WALBERTON PARISH COUNCIL

Planning application WA/50/20/RES

Walberton Parish Council would like to register an OBJECTION to this application for the following reasons.

PLOT 6
FLOOR PLANS AND
ELEVATIONS

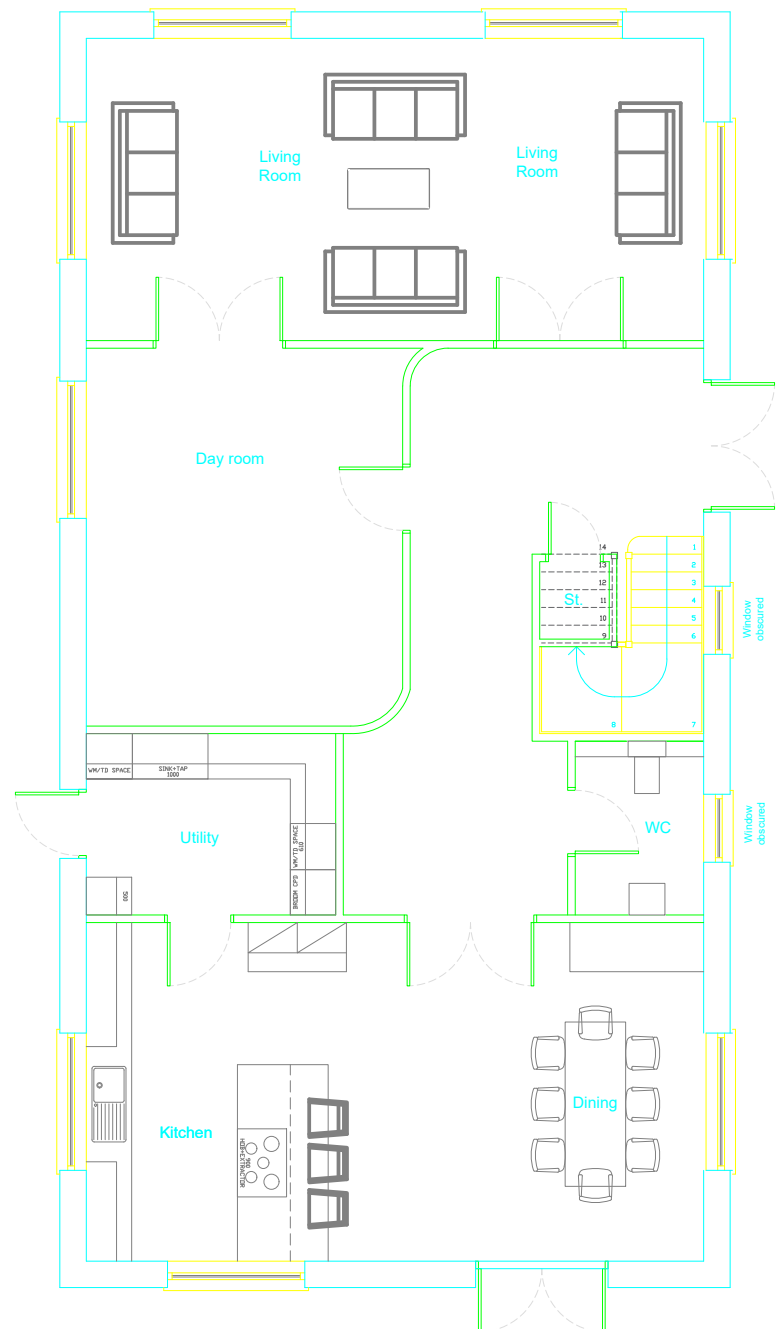
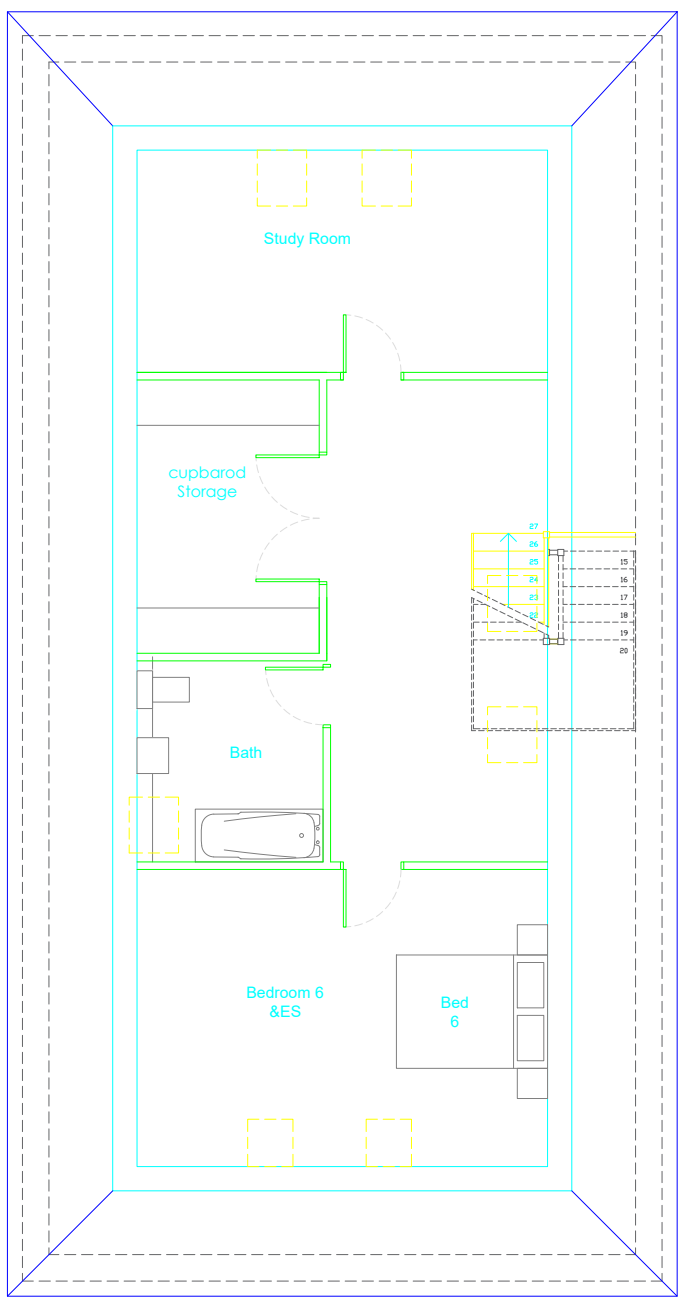
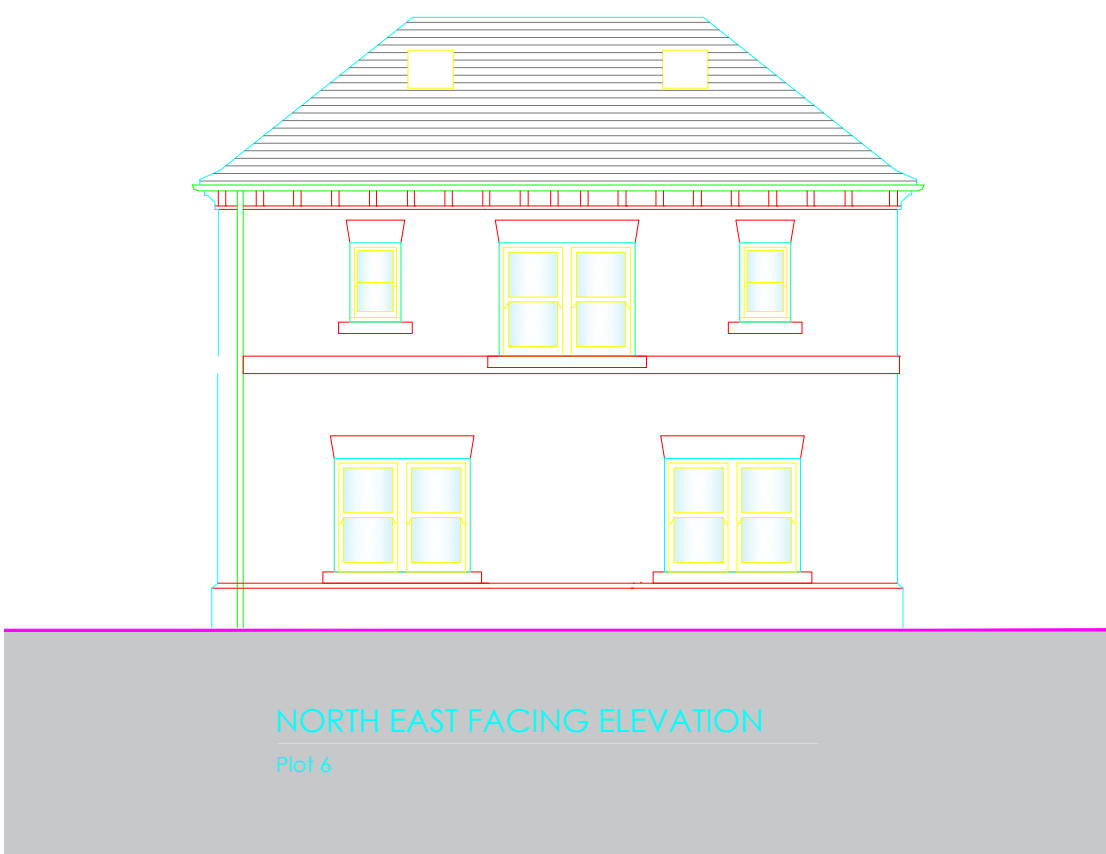
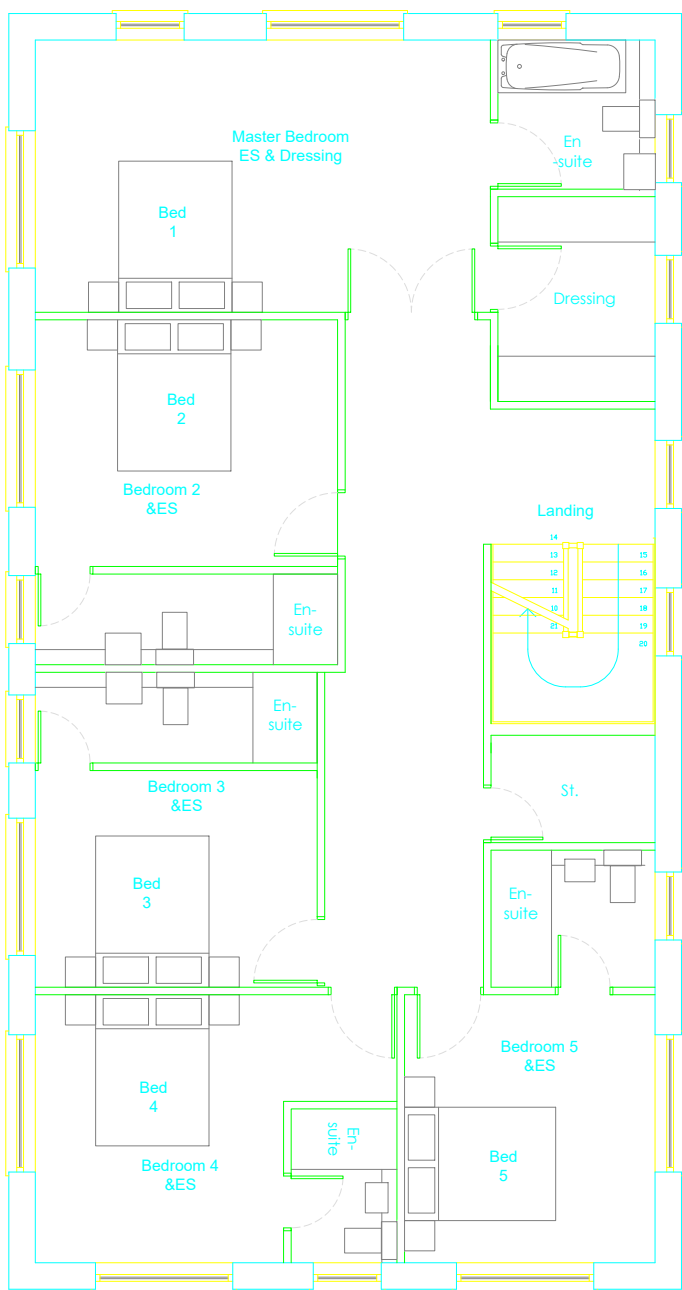
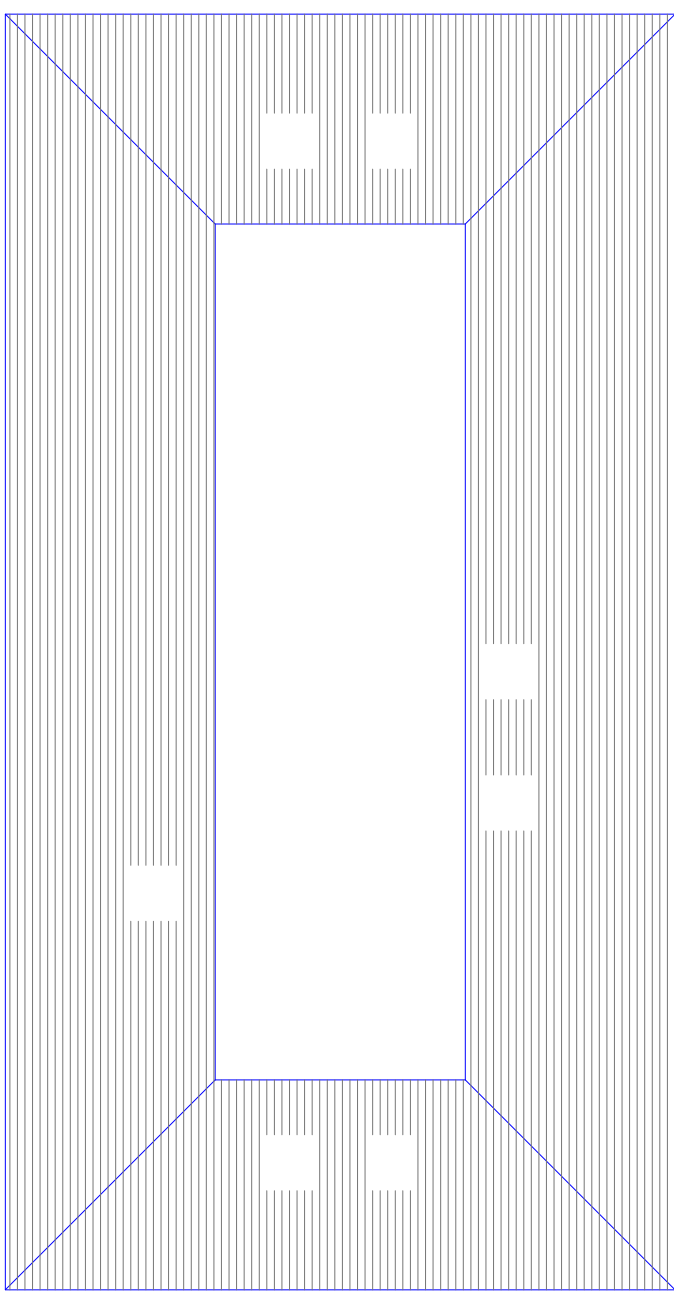
- a. The only change is dormer windows becoming rooflights. The overly formal layout of the site was criticised in the report and has not changed.
 - b. The loss of vegetation between plot 6 and the neighbouring property worsens the intrusion of the overlooking windows of plot 6.
- Policy D DM1 Aspects of form and design quality
 - a. Section 7, Trees and Woodland, states, “All new development will be expected to incorporate existing and new tree planting as an integral part of development proposals”
 - b. Significant reduction in existing planting is still proposed.
